4 January 2024

Our Ref: 2024/003951
File No: R/2023/22
R/2014/7/C

**USYD and RPA Sydney Biomedical Accelerator Project
Advice on SSD-55388456 – Environmental Impact Statement**

Figure 13 | Eastern elevation (approved CIP envelope dashed orange) (source: RF12)

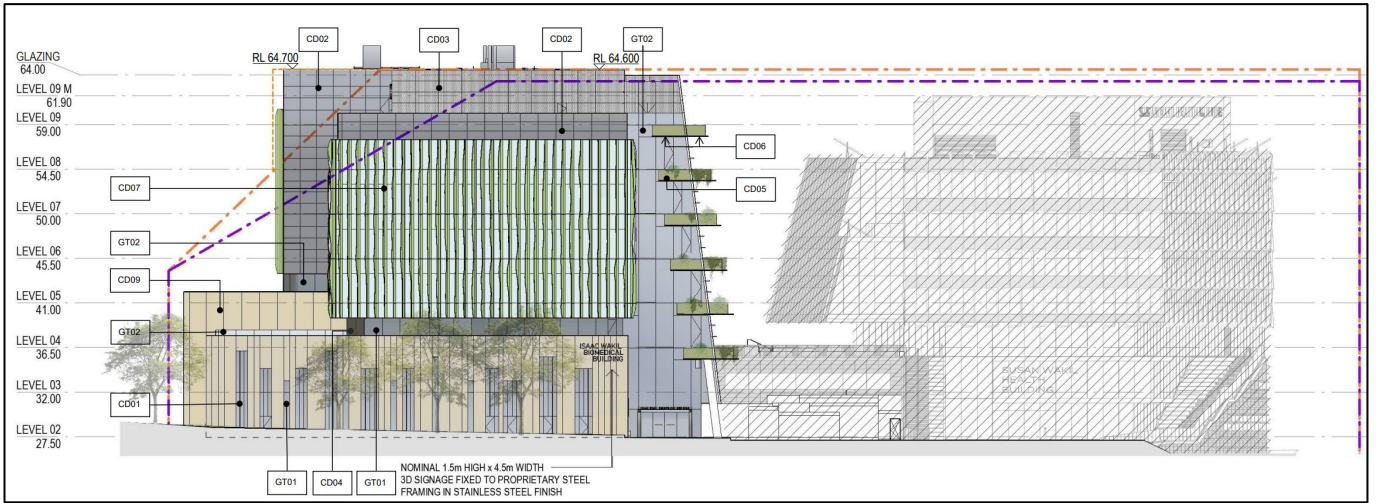
Landscaped planters along the eastern and western elevations adjacent to the raked northern facade are shown in the submitted montages, however, have not been detailed in the submitted architectural plans (refer to figure 1 & 2 below). Should the intent be to wrap around the landscaped planters than the architectural plans should be amended to detail this element and ensure the feasibility of the proposed landscaping as addressed additionally above.

Figure 19 | Landscape design (source: RtS)

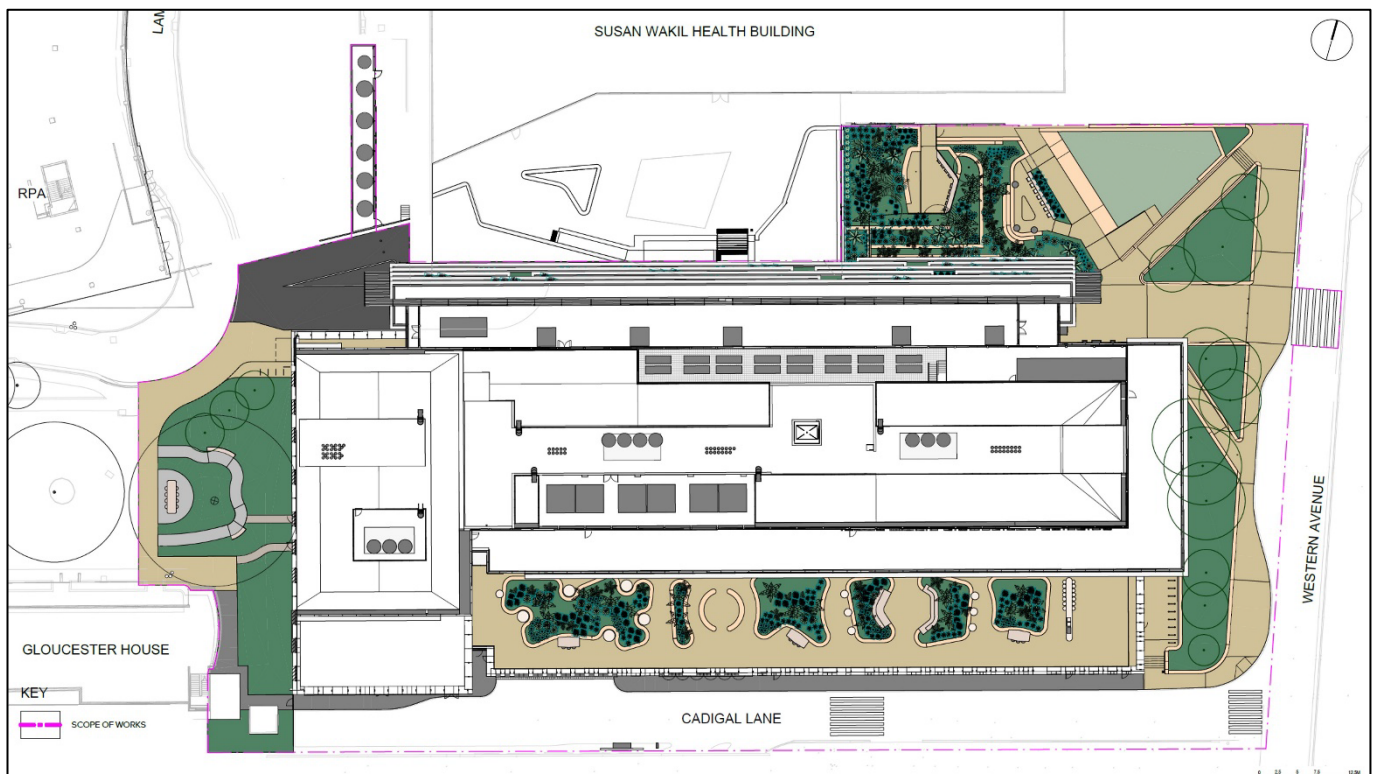
Detailed landscape plans have not been submitted as part of the application. The Landscape Design Report, prepared by Arcadia, dated September 2023 does not provide sufficient detail or clarity to properly assess the design and viability of the

proposed landscaping. It is noted that several plan, section and detail extracts are also illegible and that there are several discrepancies between the landscape report and architectural plans that should be resolved. Further details are required on this matter.

Tree planting within the 'Hill' includes predominantly palms and ferns with no new trees. Consideration should be given to planting canopy trees within this location to contribute to urban canopy cover targets.

Consideration should also be given to providing canopy tree cover to shade the proposed triangular courtyard "Kangaroo Lawn" to improve the amenity of this space.

Figure 23 | Level 1 floorplan

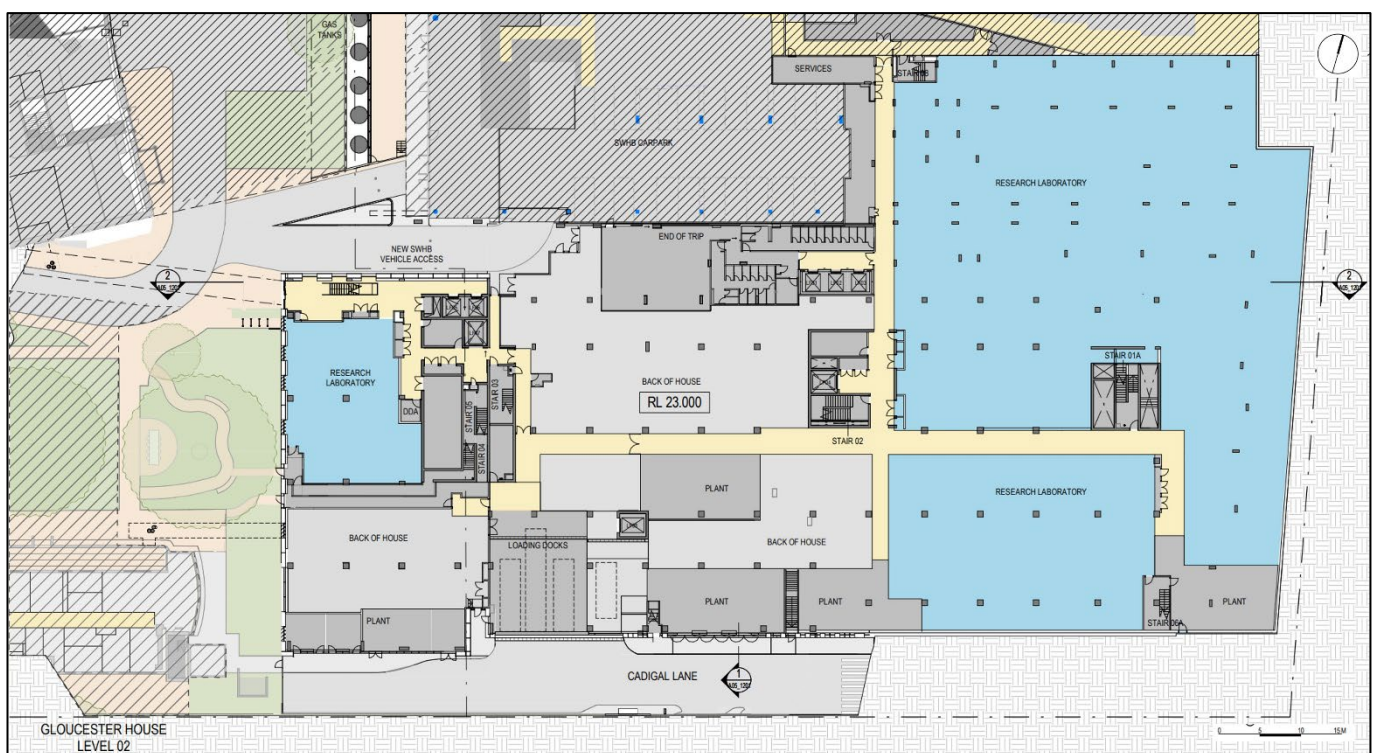
Vehicle access to the SBA and SWHB is proposed to be relocated through the adjoining Royal Prince Alfred Hospital site (RPA) from Missenden Road, via Lambie Dew Drive. An appropriate restriction should be registered on the relevant property titles to ensure that legal access to the SBA and SWHB is established and maintained in perpetuity.
